MEMORANDUM

DATE: January 9, 2023

SUBJECT: P-22-012 –Sterling Ranch East RS5000
Second Submittal

REZONE EXHIBIT

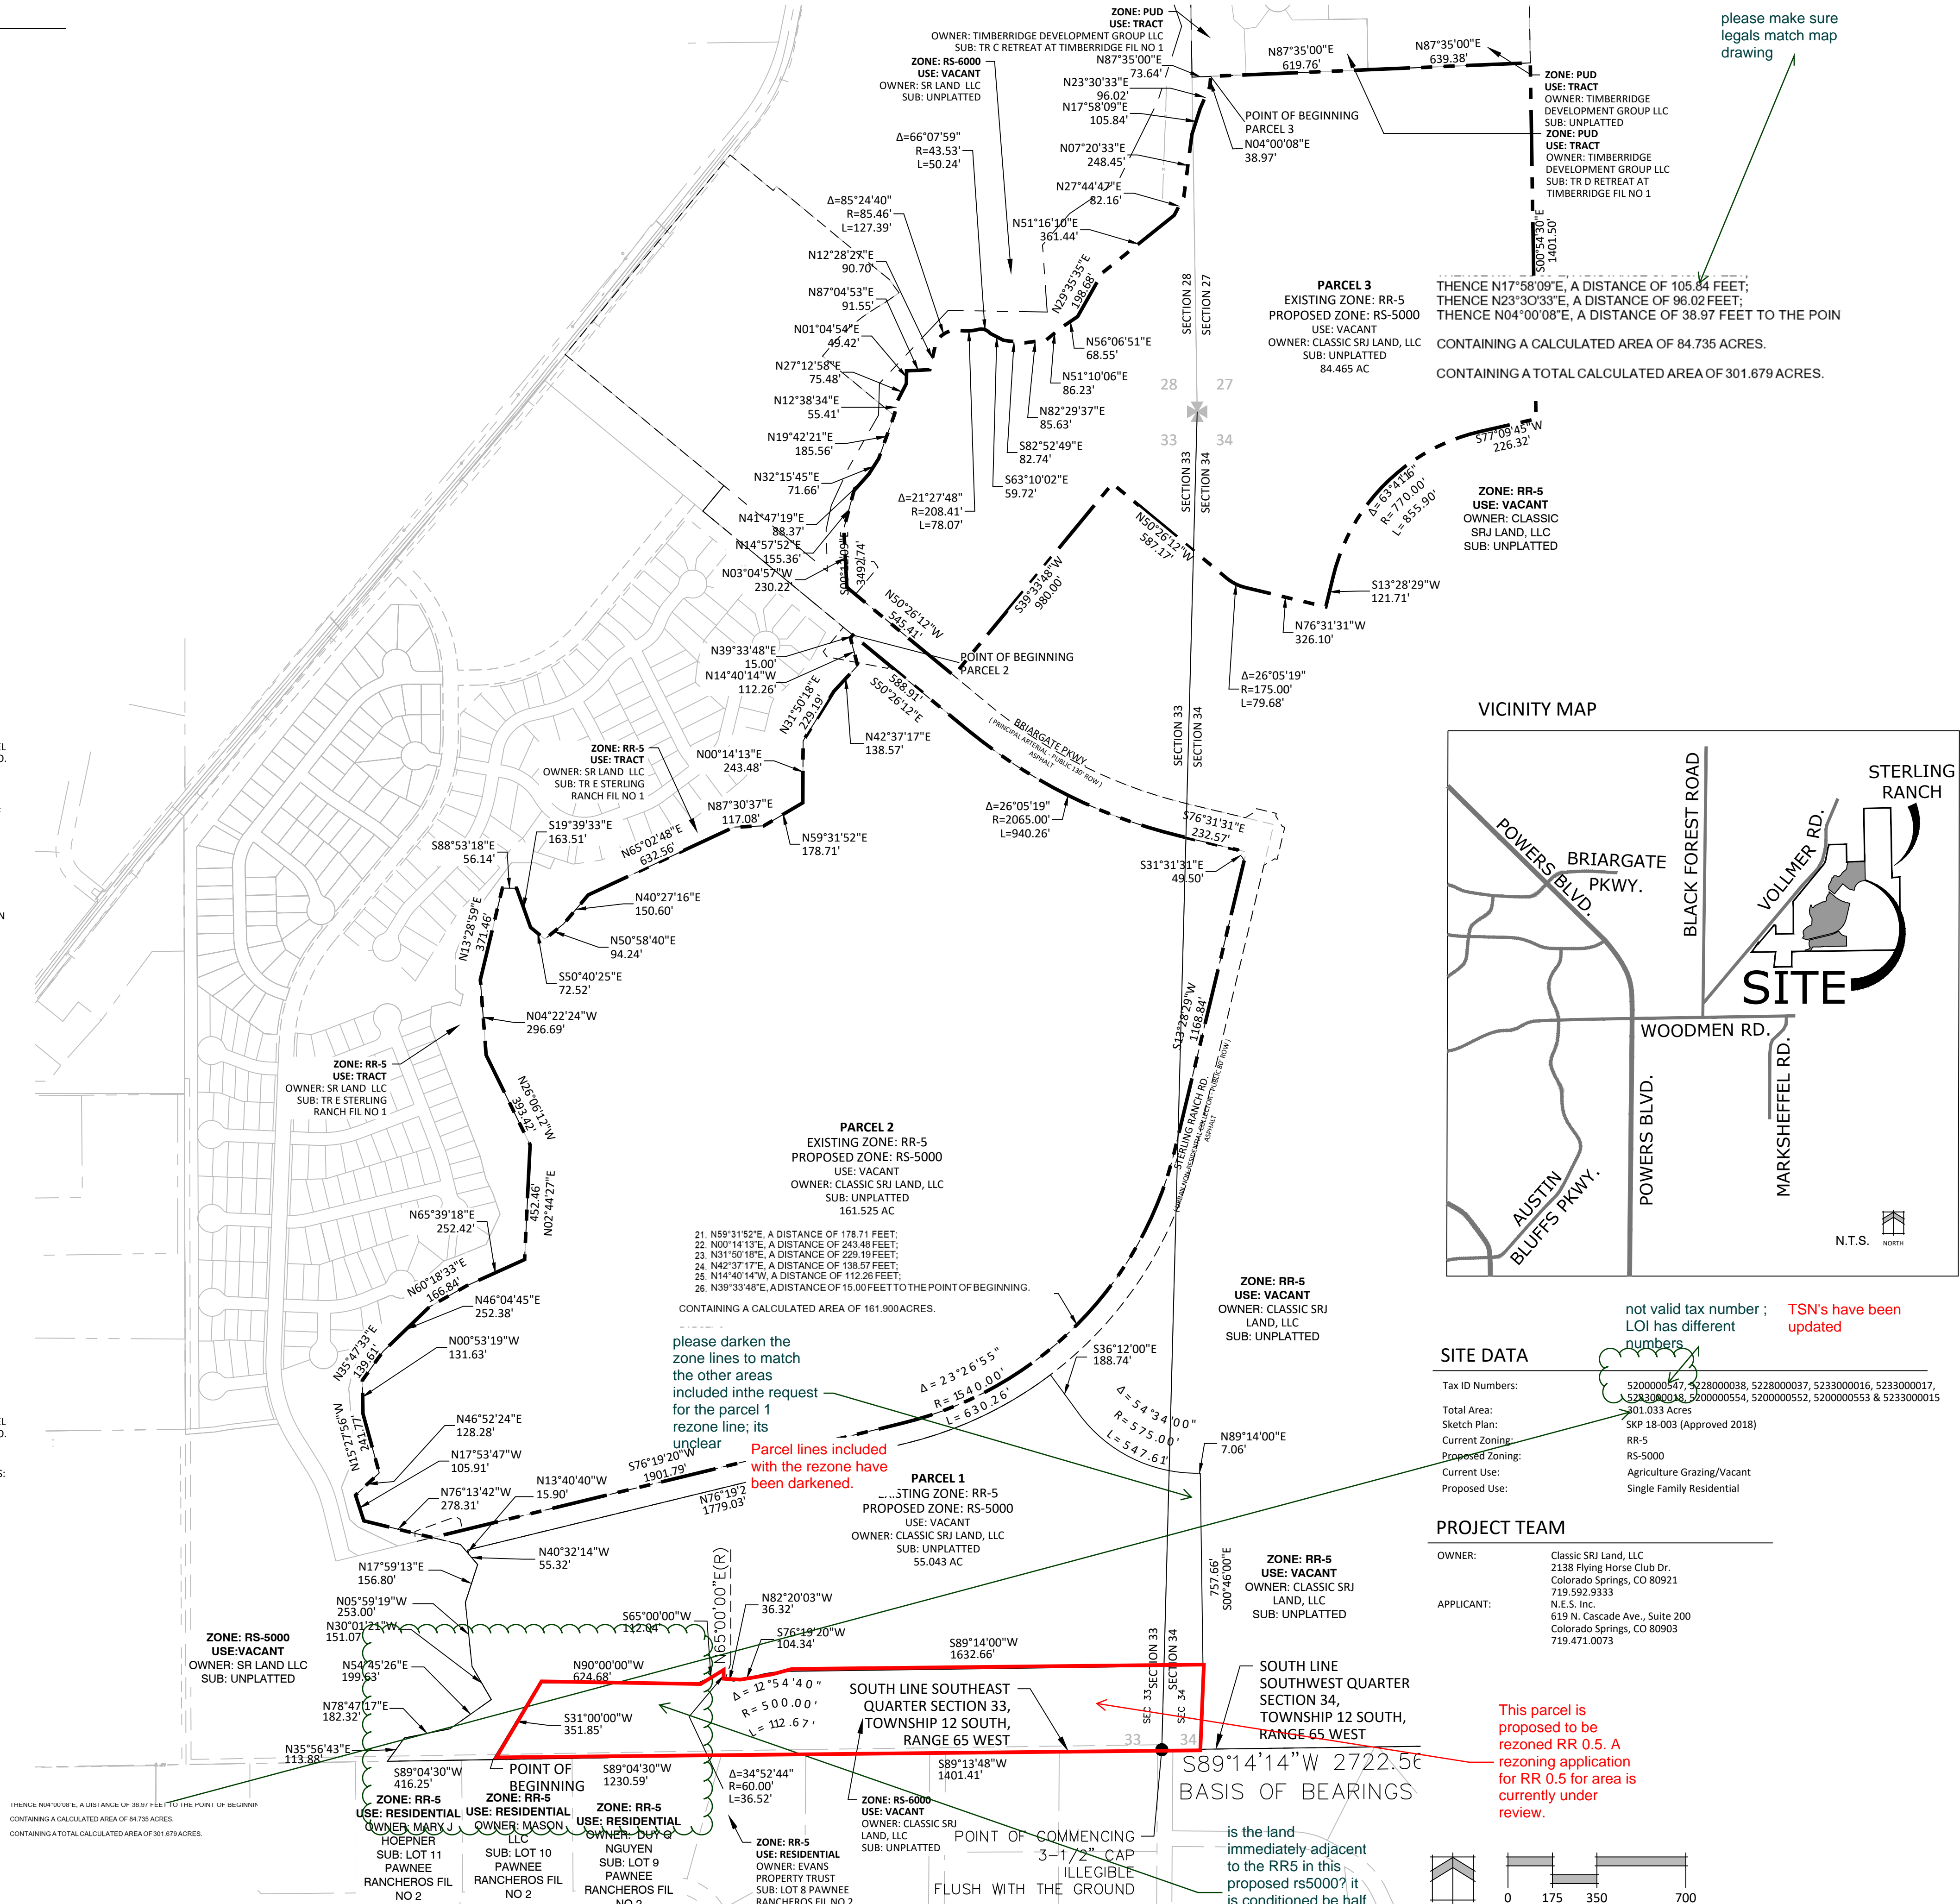
1. See **updated** Zoning Map and **Legal** redlines.
Legal and zoning map have been updated to match legal description. 301.033 AC is proposed to be rezoned from RR-5 to RS 5000. The southern boundary of the Sterling Ranch SKP plan is proposed as RR 0.5, please reference the rezoning application for this area.
